## Application for a Non-Material Amendment Following a Grant of Planning Permission

Town End Barn

1. Garage to have stone quoins on the corners to match house
2. Rear elevation of garage (facing existing substation) to be sand cement render painted to match stone
3. Slight amendment to garage position

client:	project:	drawing:
MARK EVANS	TOWN END BARN LONGRIDGE ROAD, CHIPPING PRESTON, PR3 2QD	PROPOSED SECTION

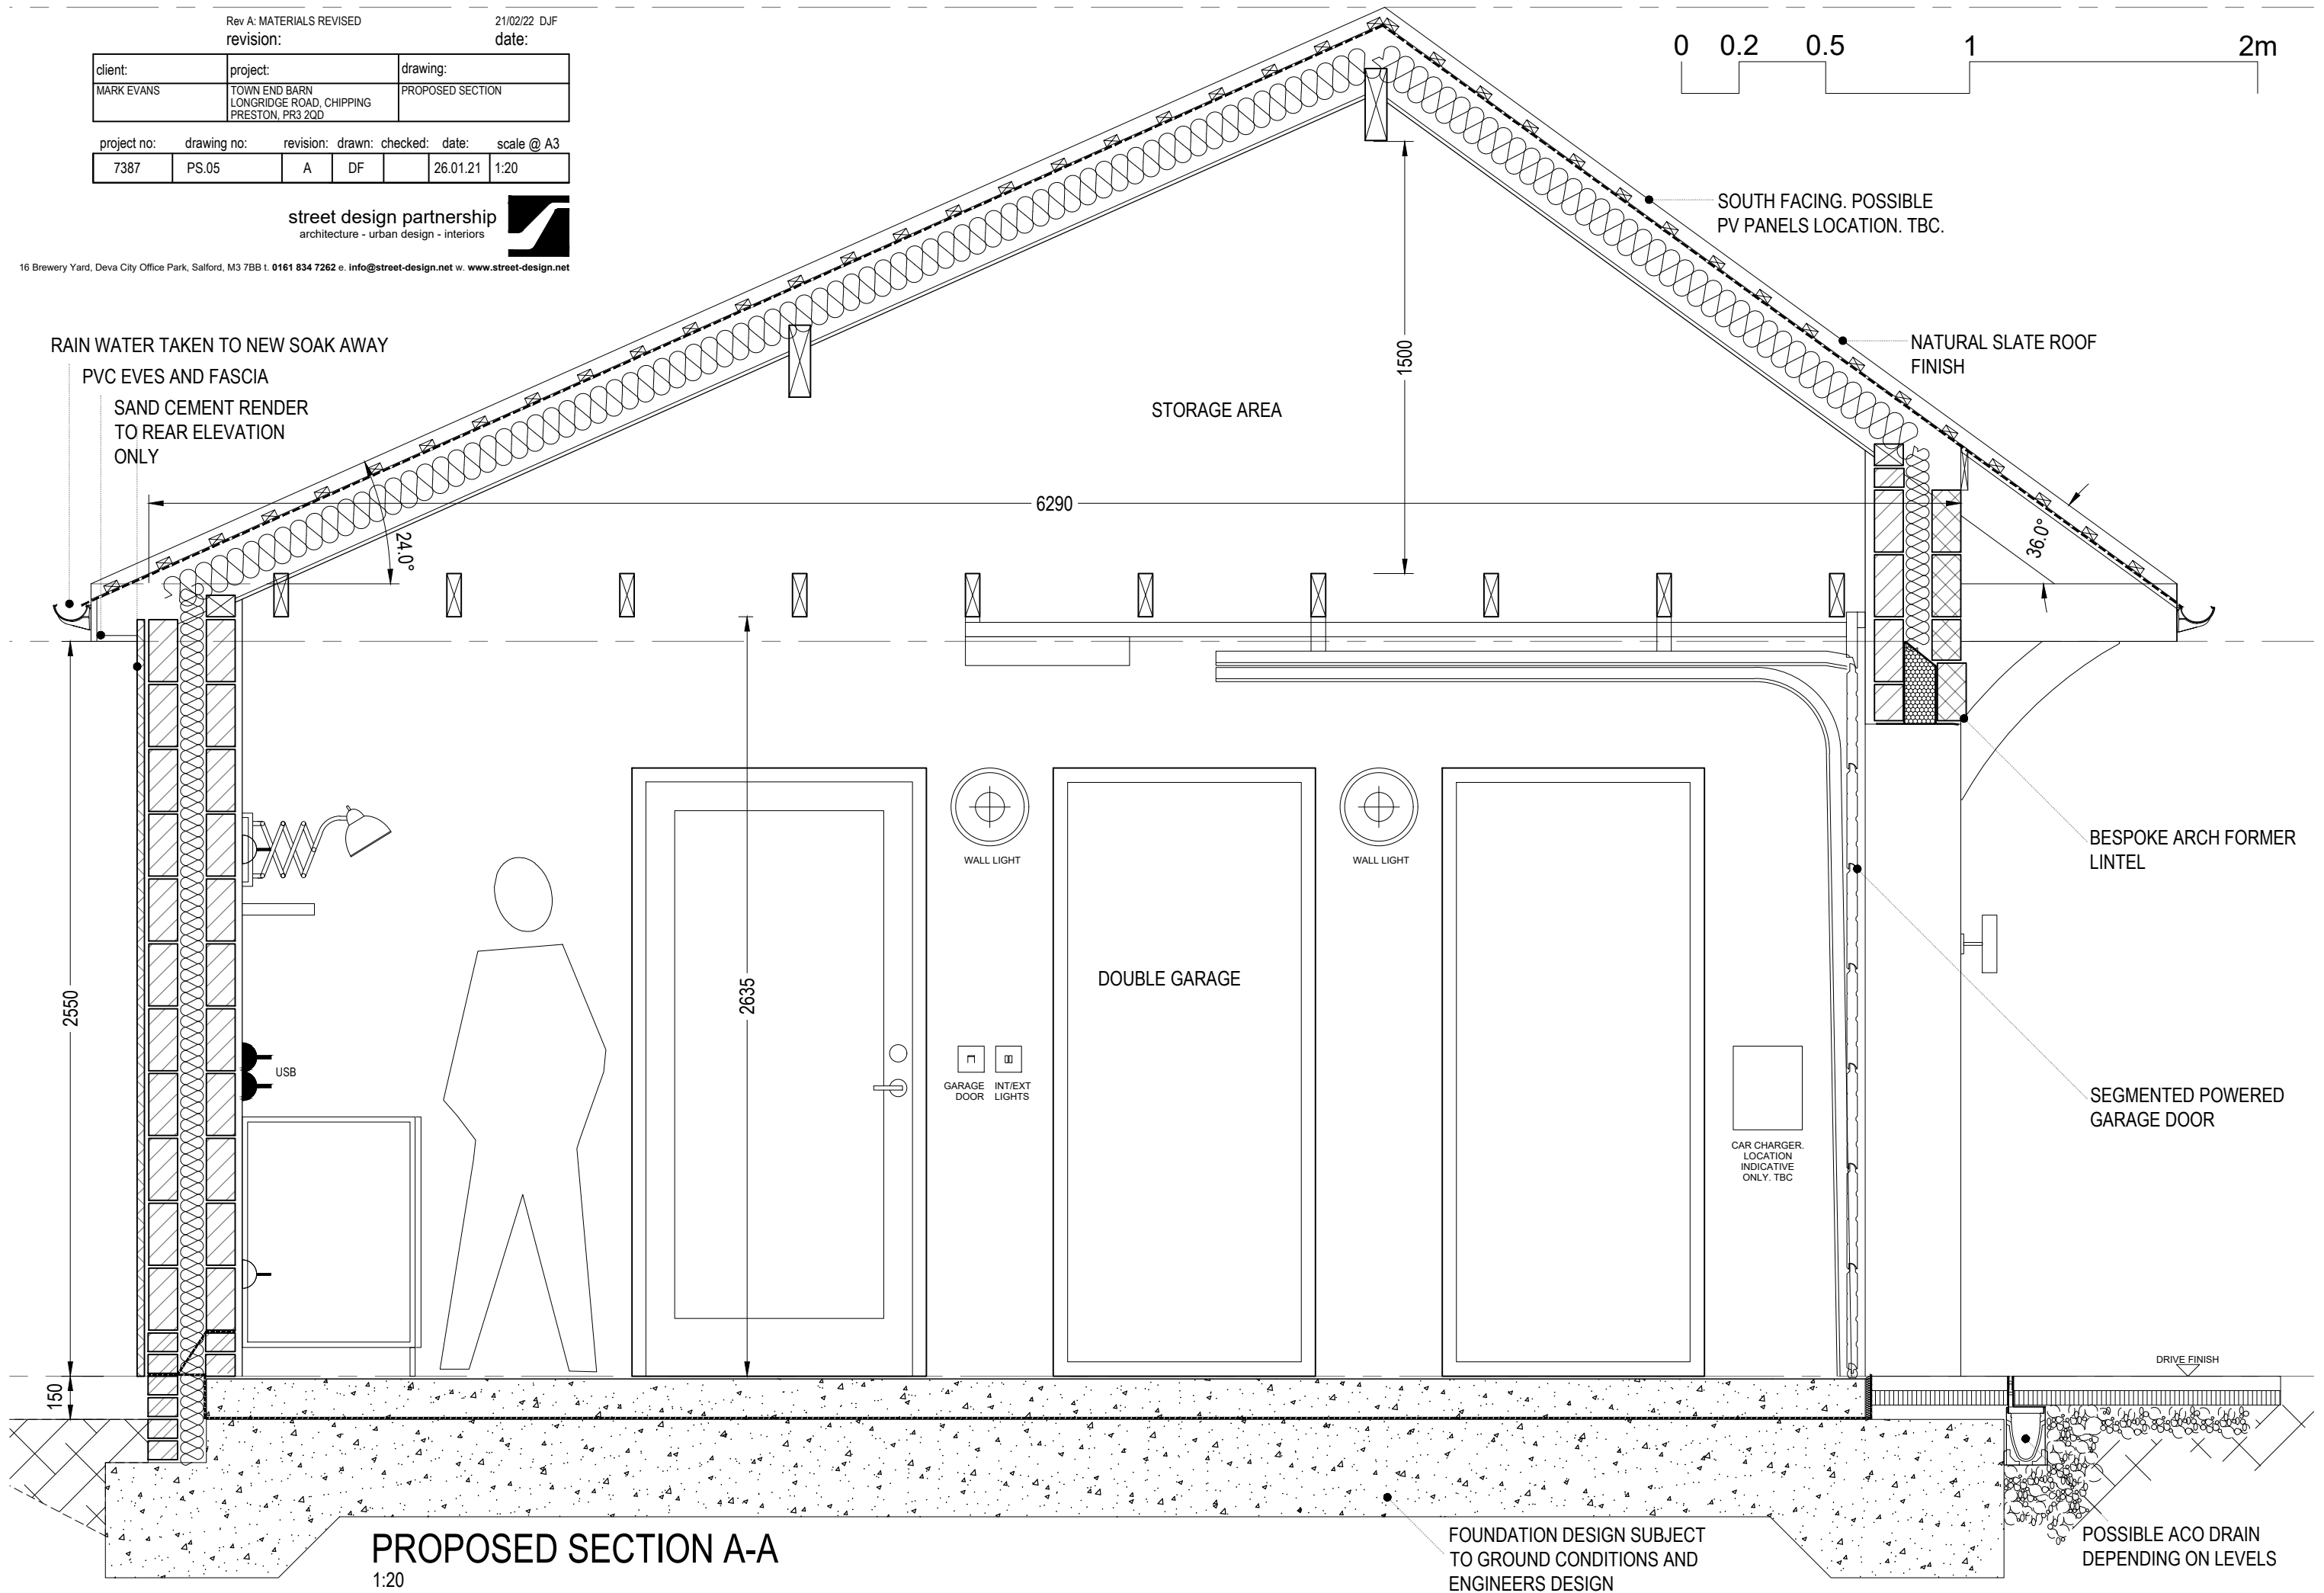
Proposed Site Plan: Dwg no PS.02A  
Proposed Plans: Dwg no PS.03A  
Proposed Elevations: Dwg no PS.04B  
Proposed Section: Dwg no PS.05A
